ADC PARKS & GREENSPACE ARBORICULTURE

PLANNING APPLICATION: A/76/15/PL

ADDRESS: Angmering Manor High Street Angmering BN16 4AG

BRIEF DESCRIPTION: Erection of single storey rear extension & re-modelling of front car park area to increase number of spaces from 25 to 32. This application affects the character & appearance of the Angmering Conservation Area.

Drawing Number TPP 15/956 001 Rev -

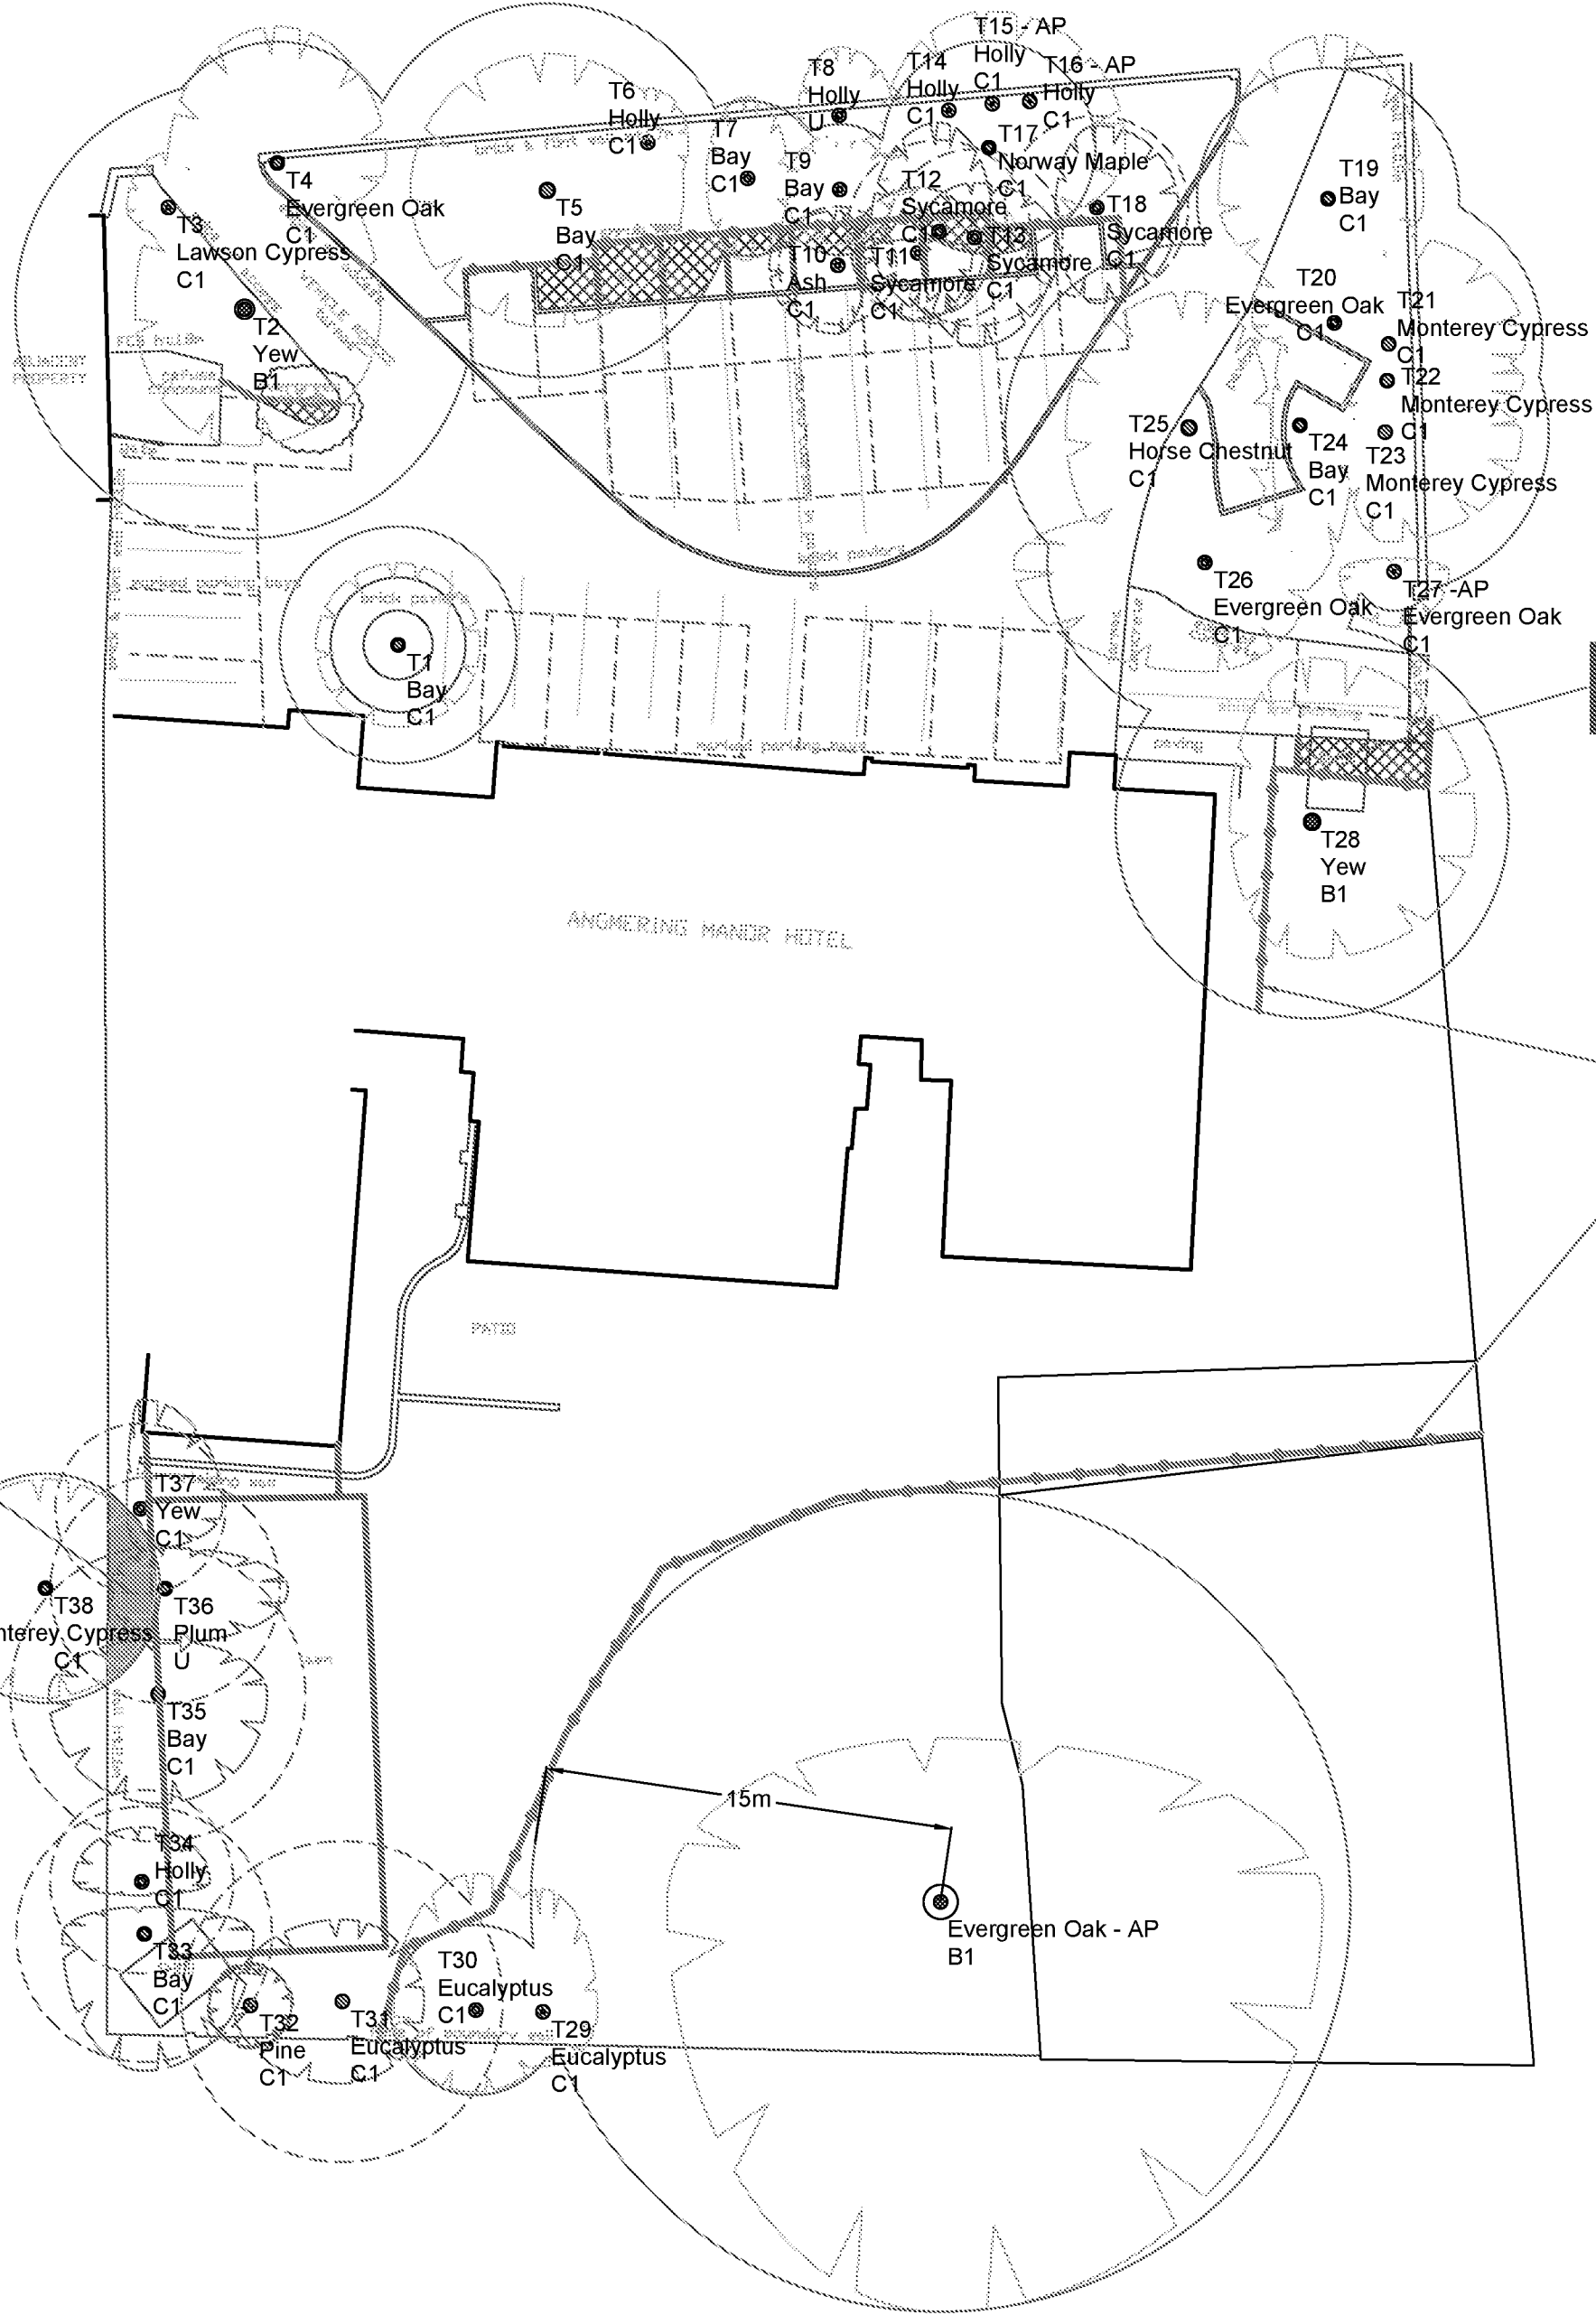
- The submitted application refers to the erection of single storey rear extension & re-modelling of front car park area of Angmering Manor.
- The applicant has outlined the desire to remove trees **T10, T11, T12, T13, T18, T31, T32, T33, T34, T35, T36, and T37**. From the site inspection it is clear the loss of these trees would have a significant impact on the landscape. All trees listed for removal were assessed for the suitability for tree preservation orders. The only specimen that scored reasonably high on the TPO assessment was **T37**. This tree scored a 10 – which is just short of qualifying for a TPO (the tree scored high on retention span; however the active suppression has had an adverse effect on the form and condition). The loss of the cited trees would require mitigation replanting, as not to lose the character of the wider landscape.

- The applicant has also applied to reduce the lateral spread of **T5, T7 and T9**, to facilitate the proposed parking bays.
- The applicant has also outlined the desire encroach the RPA's of retained trees with hard surfacing for the proposed parking spaces. This proposed membrane will affect **T2, T5, T7, T9, T17 and T28**.

- Once the protective fencing has been erected, the Local planning authority arboricultural officer must be contacted to ensure the fencing is correctly placed. This fencing must be erected and kept in place for the duration of the development works.

- When excavating for the new developments foundations any root structure exposed with a diameter over 25 mm should be retained. If the operators wish to remove roots of over 25mm in diameter, then the LPA arboricultural officer must be informed to supervise any root pruning/removal. This condition should be adhered to in completing the ground works in the RPA's of **T2, T5, T7, T9, T17, and T28.**

- The implication of effective ground protection must be achieved before any construction works commences to protect the RPA of **T38.** Again the local planning authority arboricultural officer must check this protection before the construction works commences.

- The loss of the specimens **T10, T11, T12, T13, T18, T31, T32, T33, T34, T35, T36, and T37** must be mitigated against with new planting regime. This new planting must contain at least 12 semi-standards/standards. The species for restocking should include;

- When completing the pruning operations to both **T5, T7 and T9**, the following conditions must be adhered to;
